Application for non-material amendment following a grant of planning permission

Alterations and Extension to existing dwelling and erection of garage.

DM/2023/00697

Amended site plan to Keep existing driveway entrance from Castle Street. Amended roof design to remove central flat roof.

Date	May 2023	Scale	1:100 @ A2
Drawn by	CB	Drawing No	1721[PL] 03 A
Checked by		Status

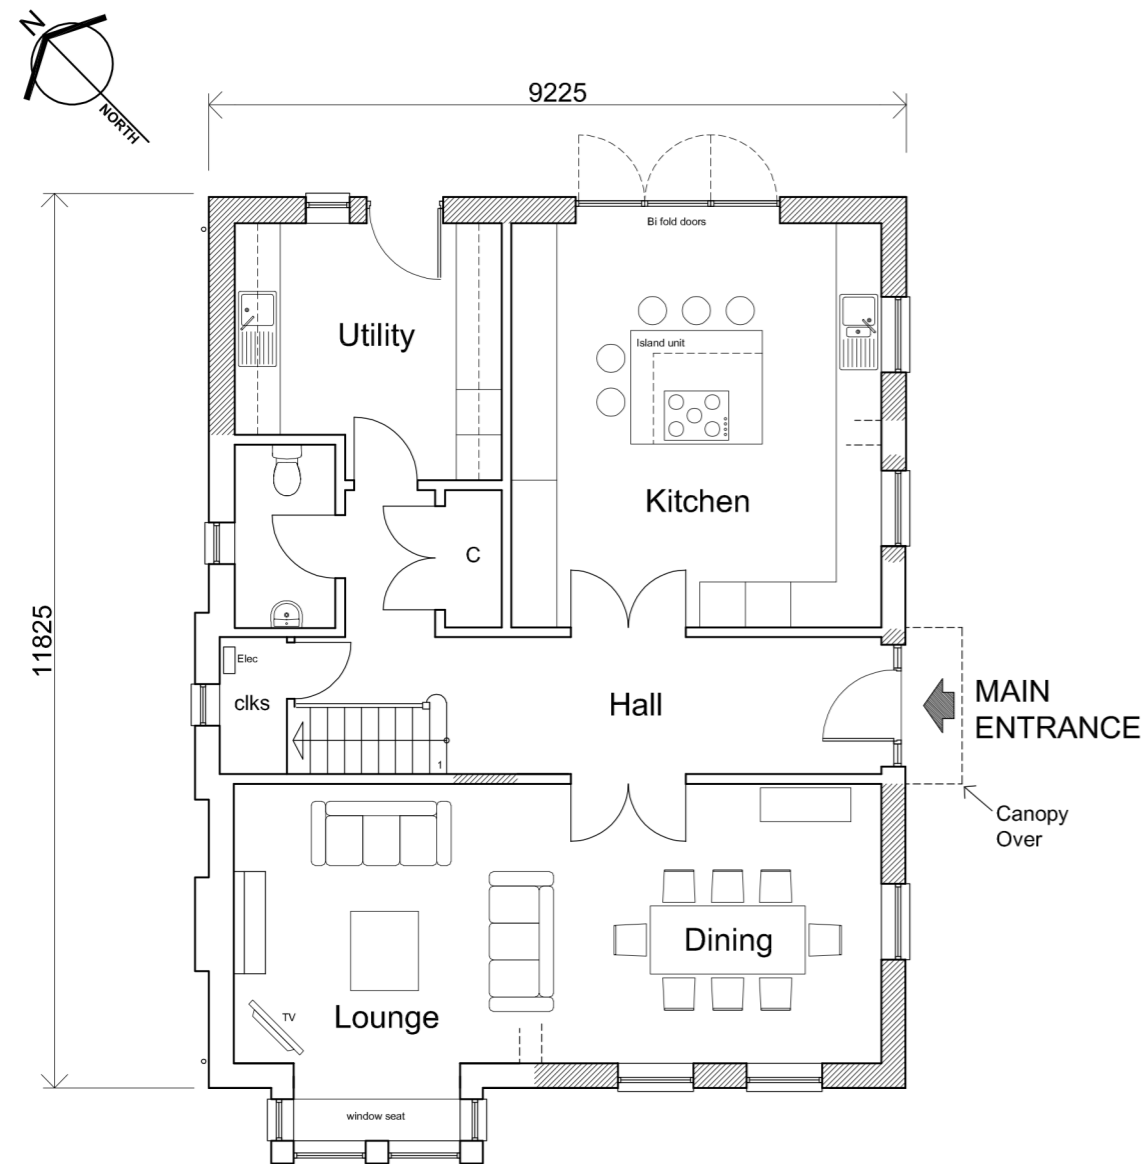
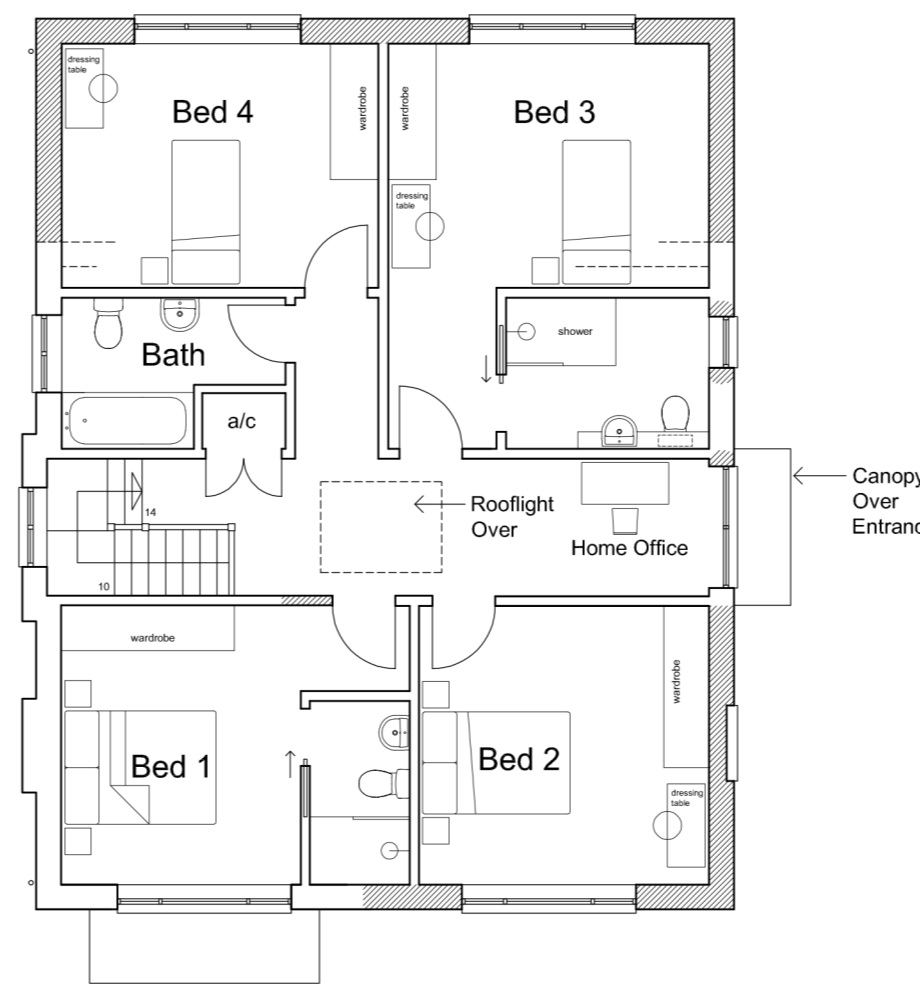
Keep existing driveway entrance from Castle Street. Simplify roof construction.
